## Any further information requested by the Examining Authority under Rule 17 of the Examination Procedure

From the examining inspector's letter of 14/10/2025:

Representative Viewpoint 37a: View looking east from footpath 152/6/10 at east bank of River Evenlode

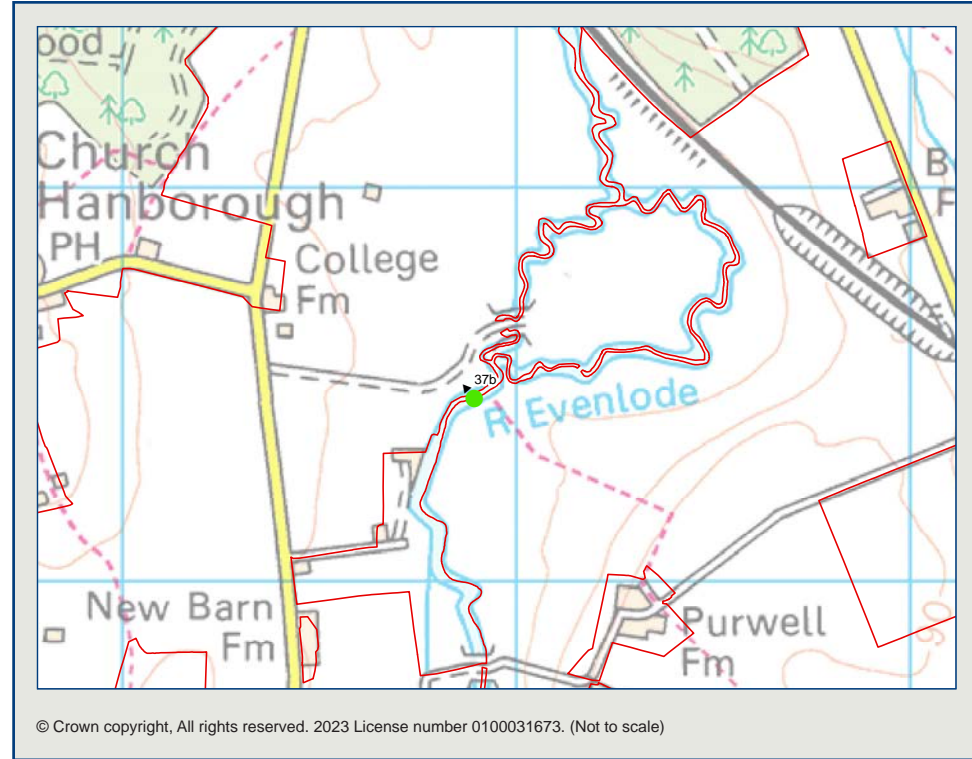
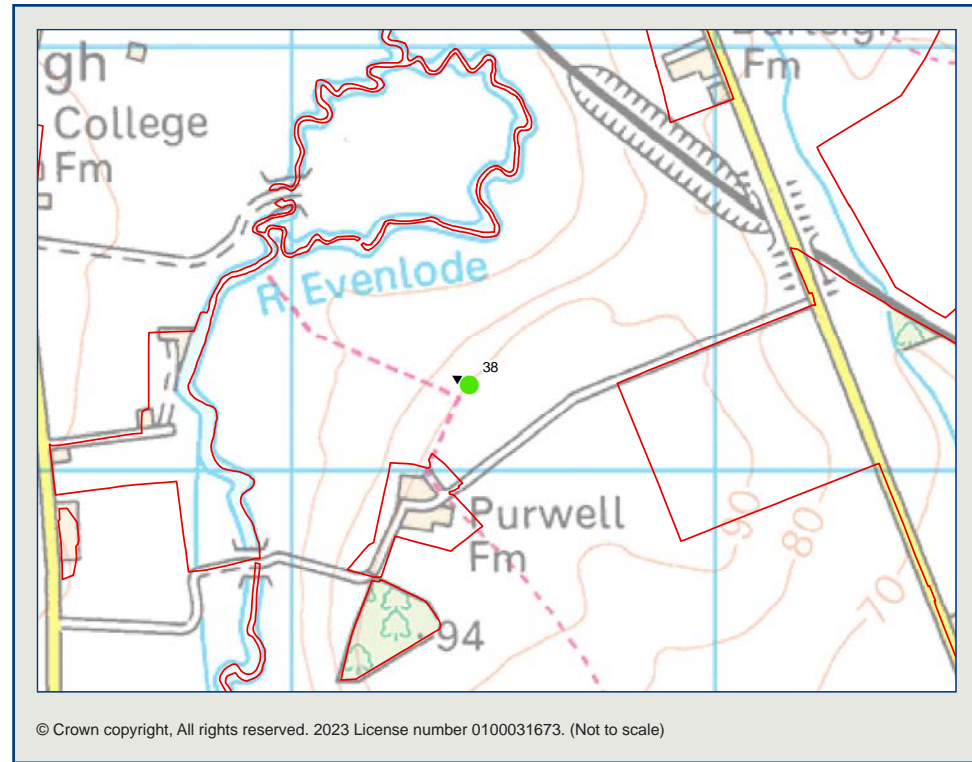
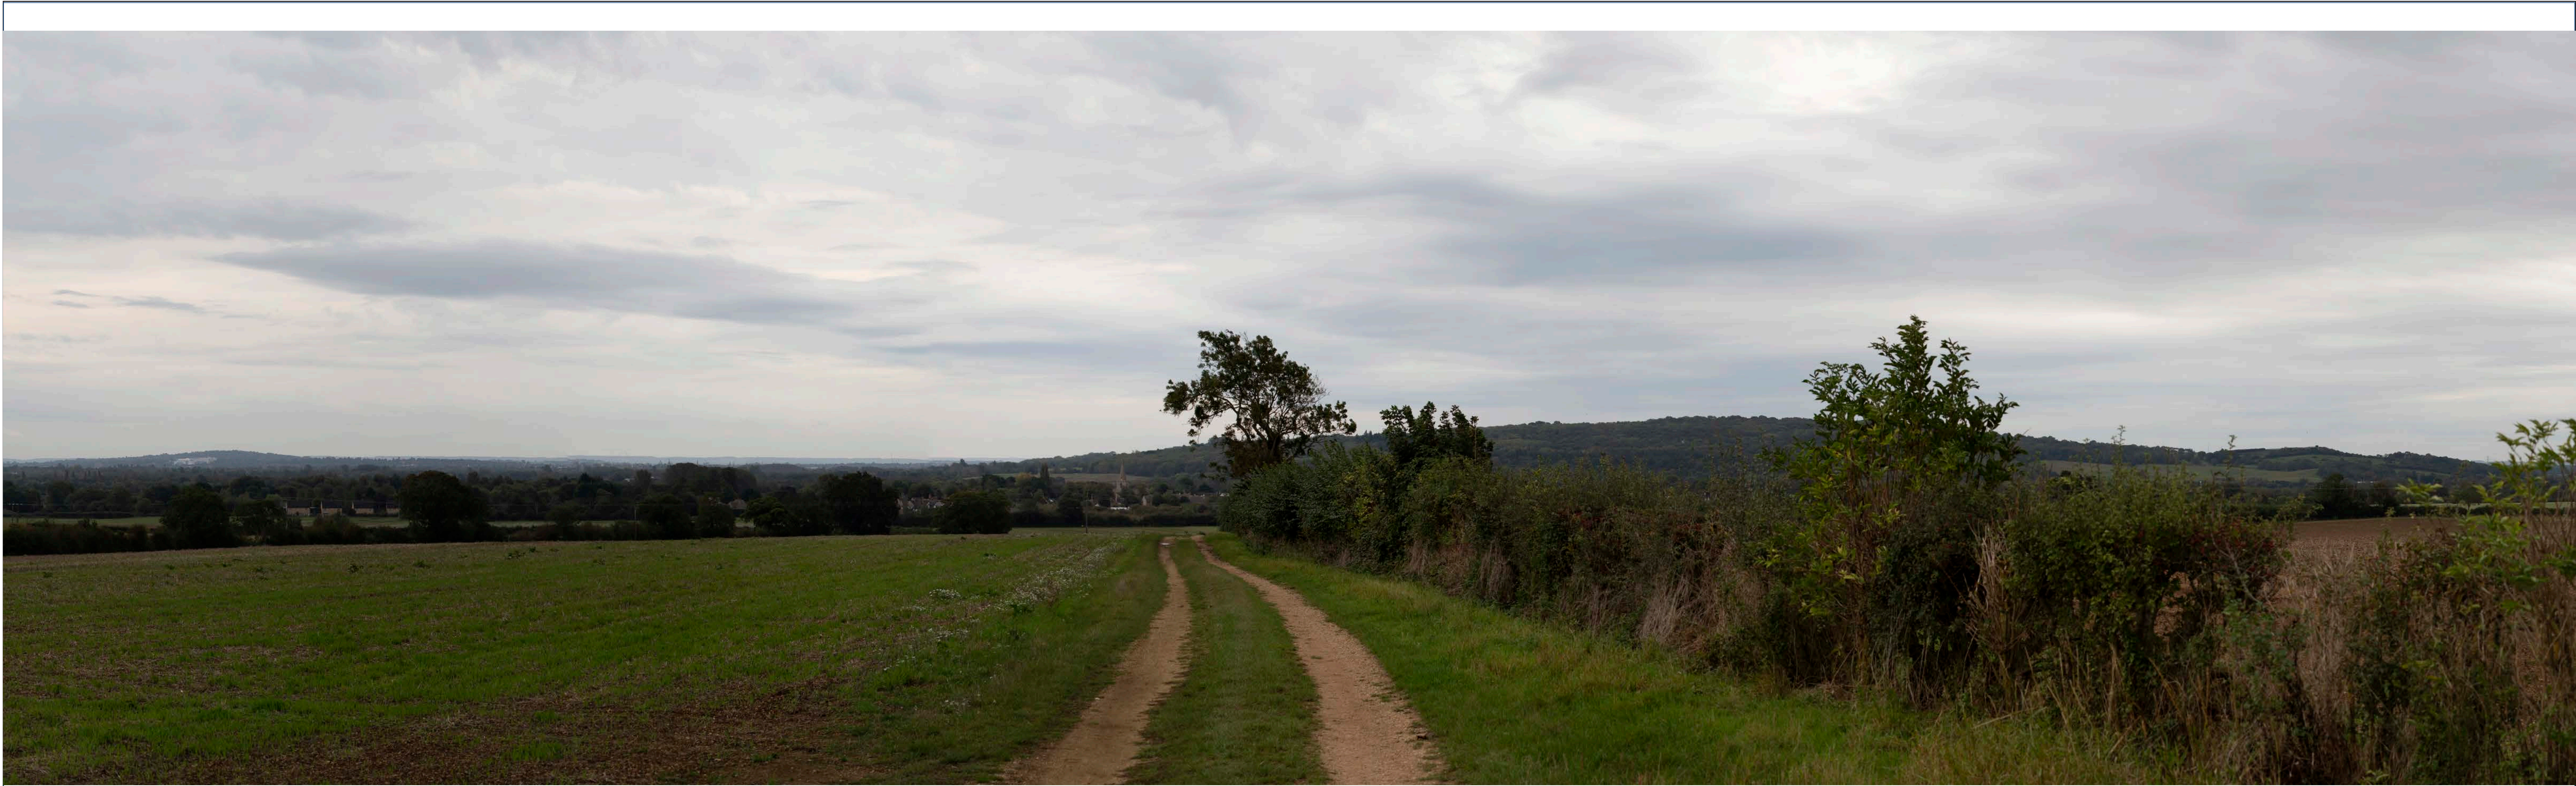
Points 11 & 12: The proposed mitigation of 3m hedges and provision of the 5m width of footpaths is inappropriate and non-representative of the footpaths in the area I have personal knowledge of, where sweeping views are more the norm. I particularly cite footpath 152/6/10 to the north of Cassington which I (and many other members of the community) use on a daily basis and which gives views across to the Column of Victory at Blenheim to the north and to the spire of (grade I listed) St Peter's church, Cassington, to the south.
